Our Reference: SYD17/00935 (A21143355)
DP&E Ref: SSD 8606

Marsden Park Warehousing and Light Industrial Estate (SSD 8606) - Lot 23 and Lot 24 DP 262886 Hollingsworth Road, Marsden Park

Roads and Maritime has reviewed the submitted documentation and the following issues are to be addressed prior to the determination of the application.

DP 262886 HOLLINSWORTH ROAD
MARSDEN PARK
PROPOSED ROUNDABOUT
SWEEP PATH ASSESSMENT
DRAWING NO. N105790-02

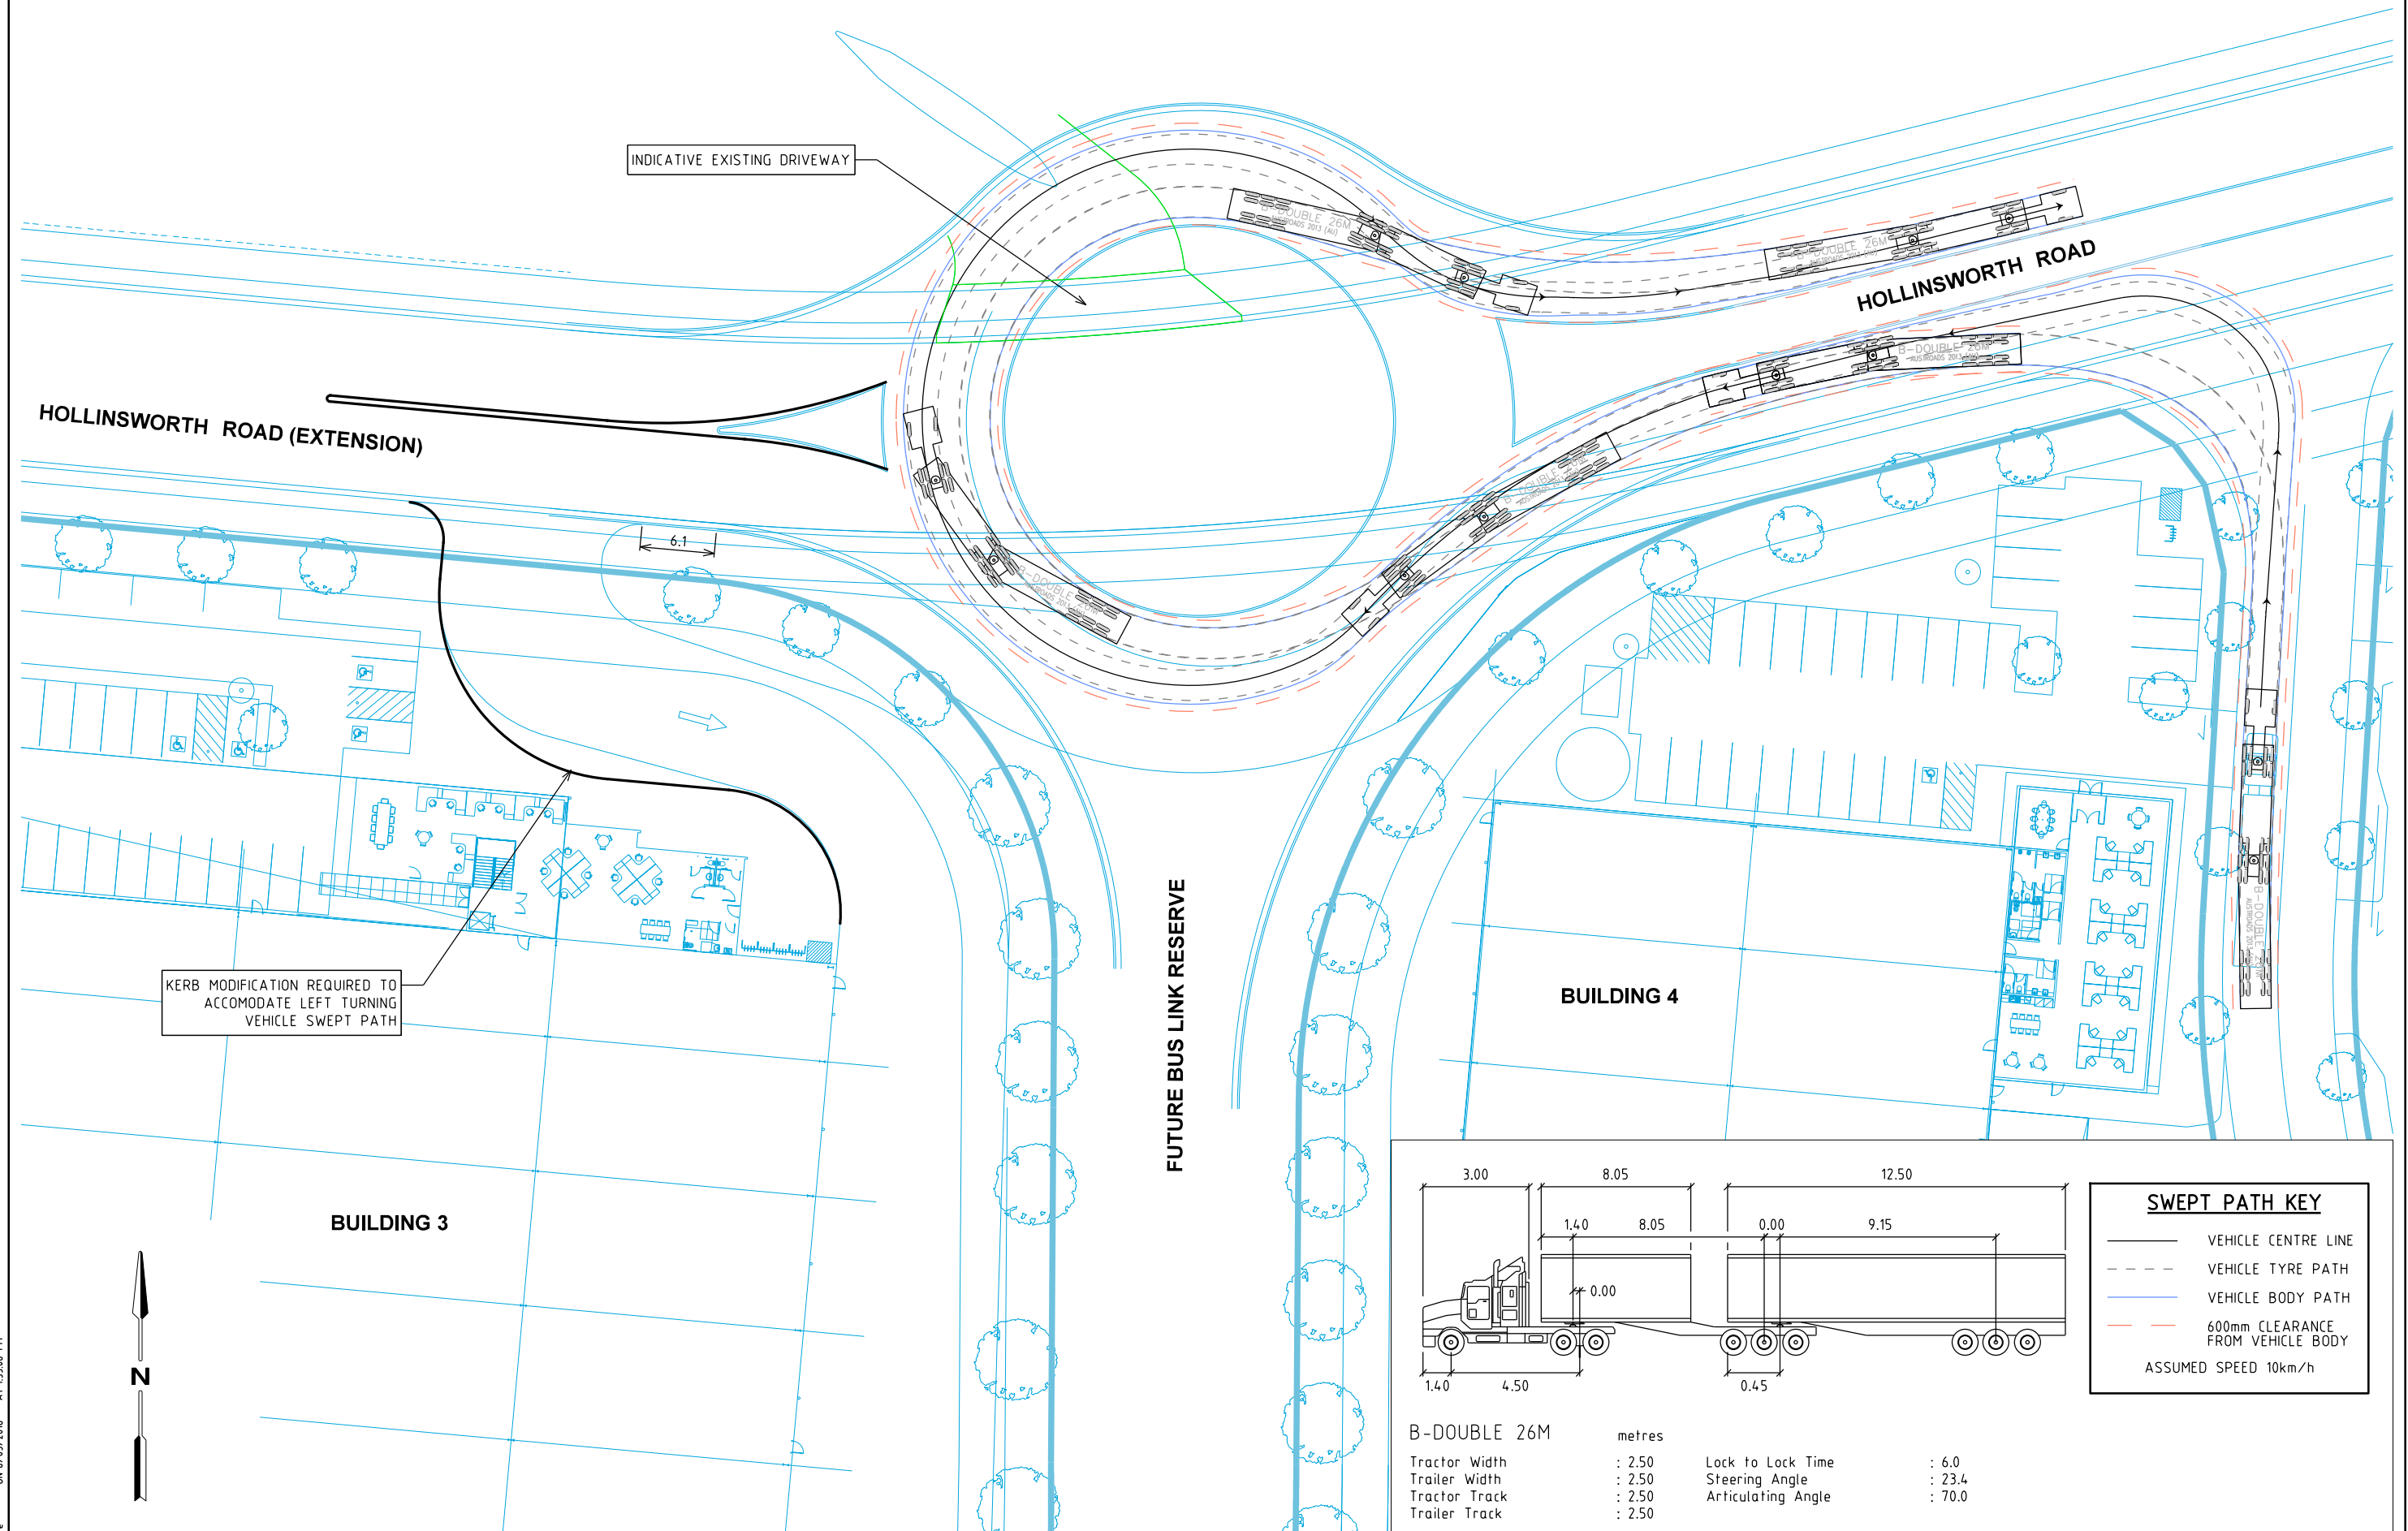
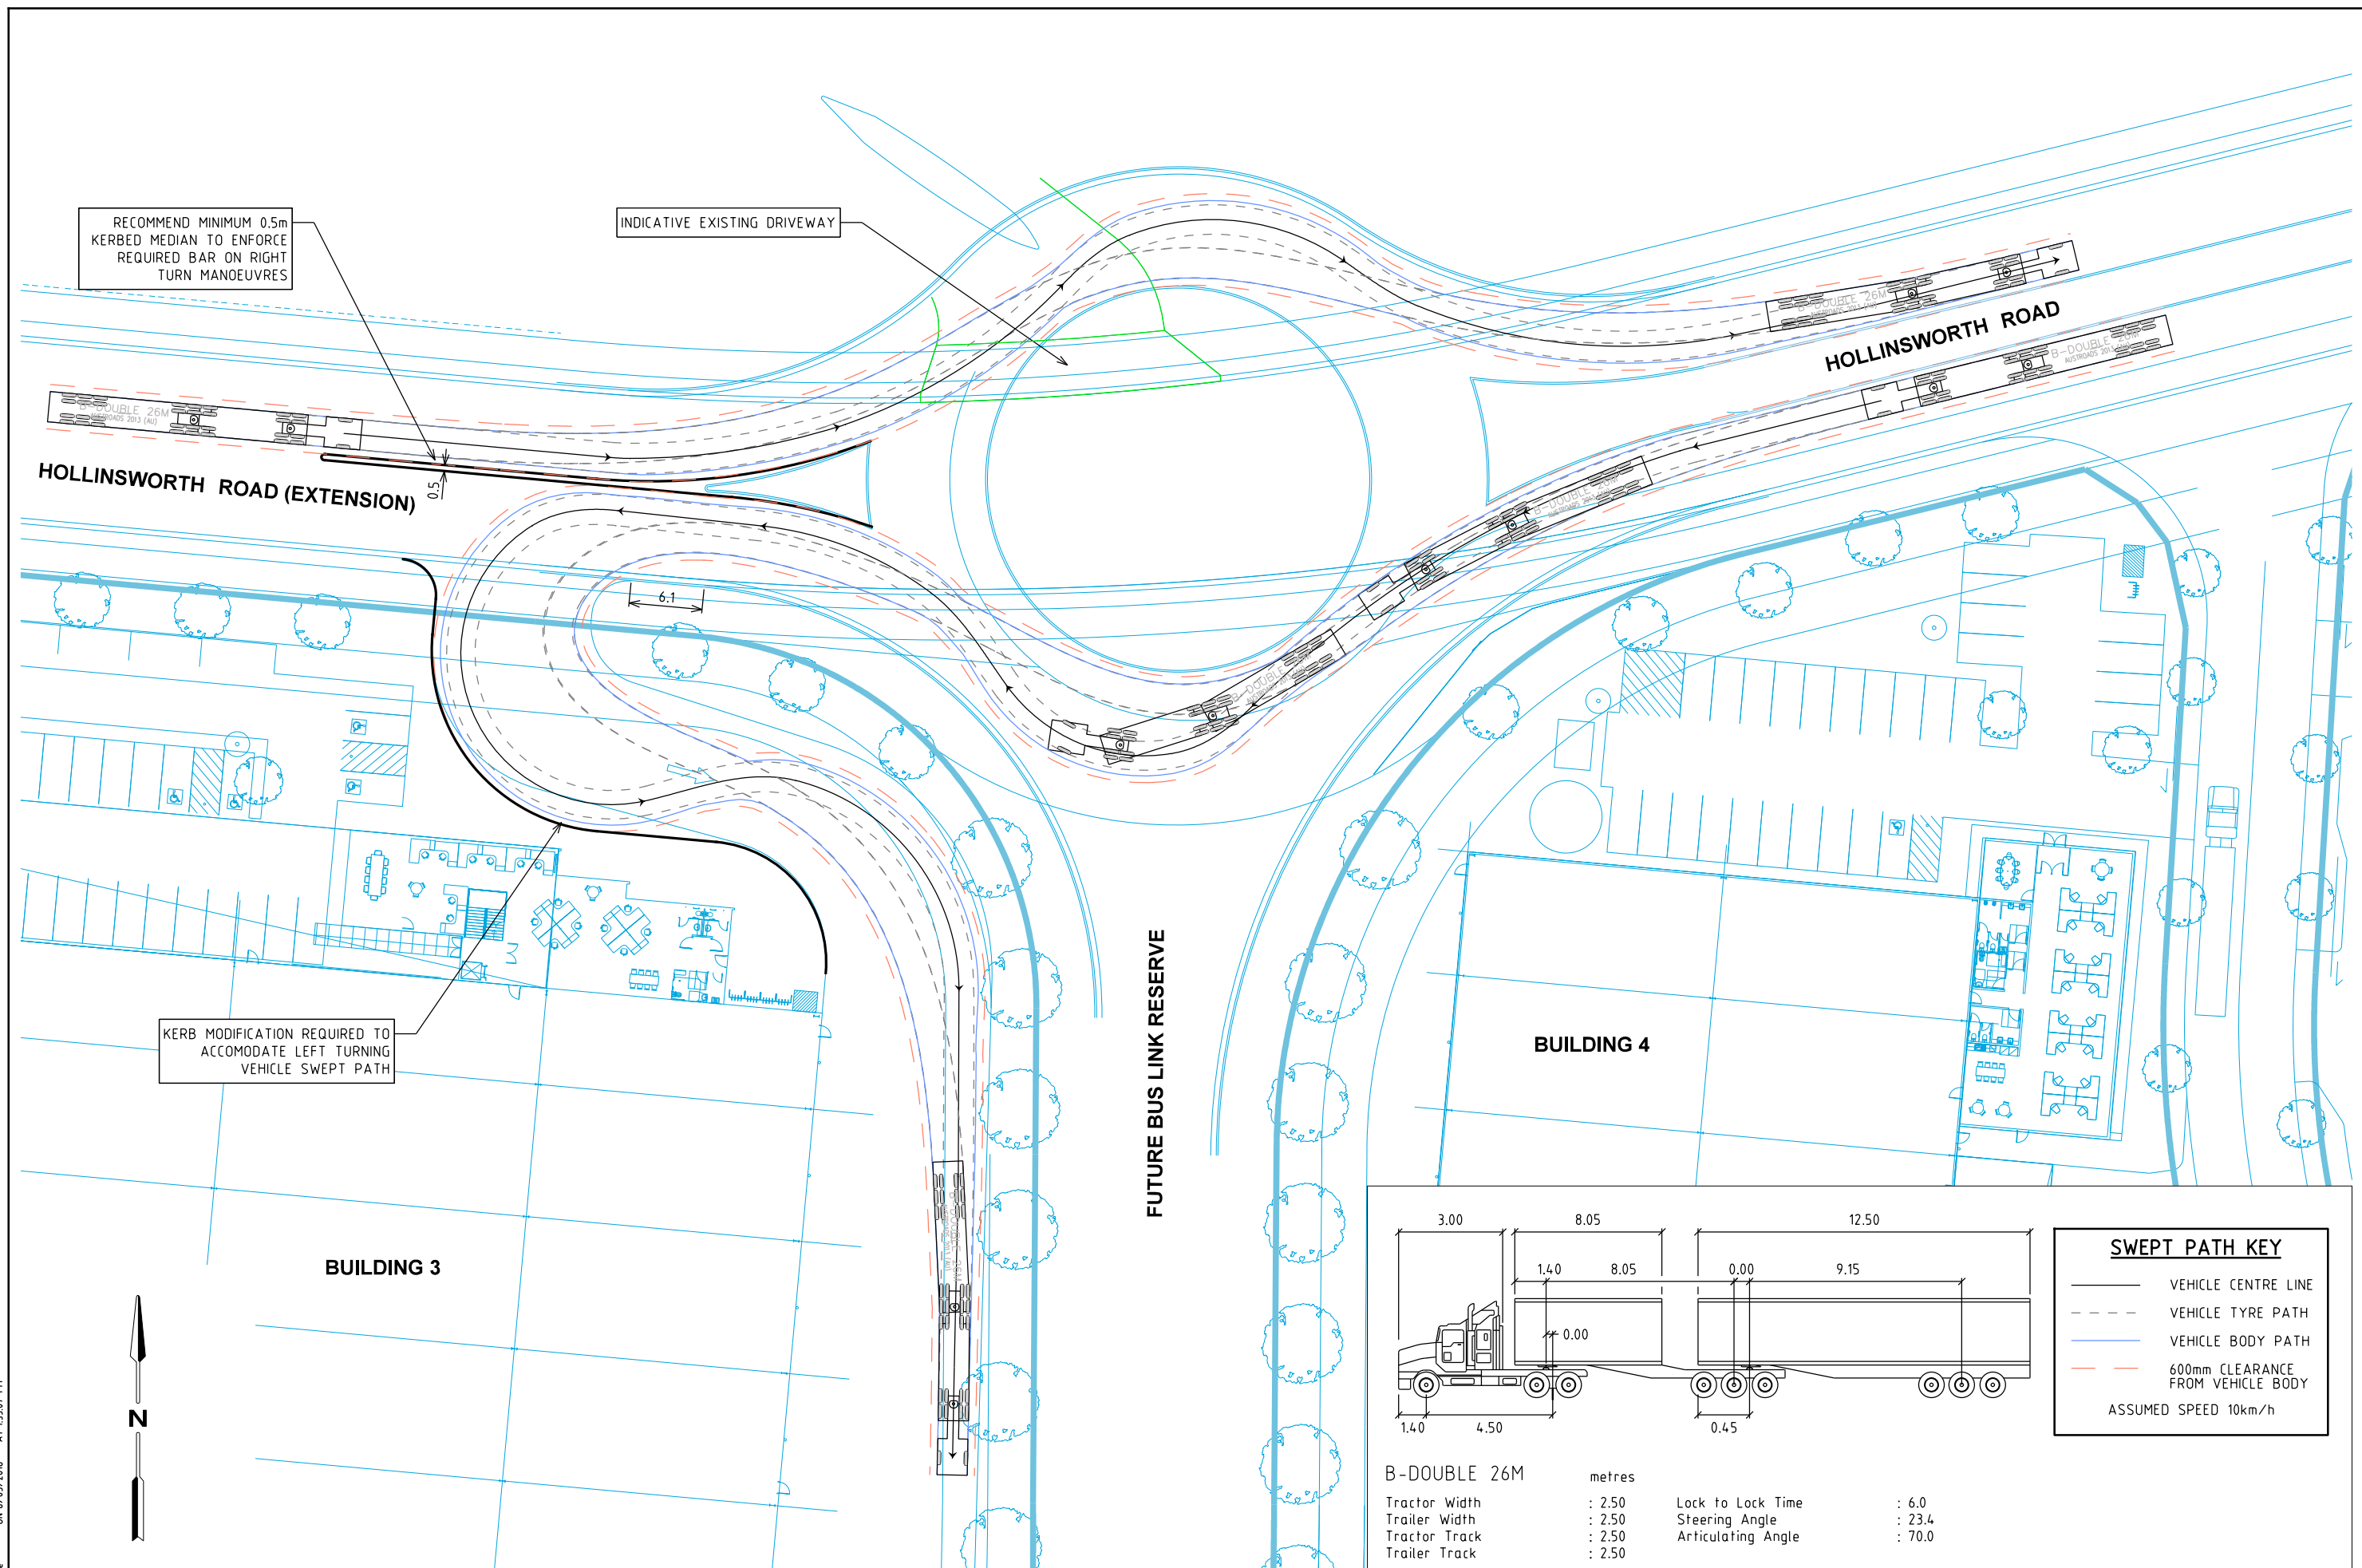
1. The traffic report refers to a roundabout at the intersection of Hollingsworth Road and Daniel Street link Road. Roads and Maritime considers the provision of a roundabout is critical at this intersection to assist in the turning movements of buses and to provide access to the existing caravan park. The intersection treatment proposed will not allow access from the future bus link as the right turn bay into the caravan park would restrict turning movements. The roundabout should be constructed as part of this development to facilitate access to the caravan park without restricting access for the bus link road into the future. The applicant should design a roundabout that can accommodate heavy vehicle movements and bus movements. The design of this roundabout should be in accordance with Austroad Road Design Guide Part 4B - Roundabouts

4. The proposed heavy vehicle access to Building Three should be restricted to left in only. It is recommended that the splitter island (for the above discussed roundabout) be extended to restrict access. The raised median is to extend 10 metres west of driveway.
5. The proposed roundabout will need to be presented to the Blacktown City Council Local Traffic Committee (LTC) meeting prior to the determination of the application.
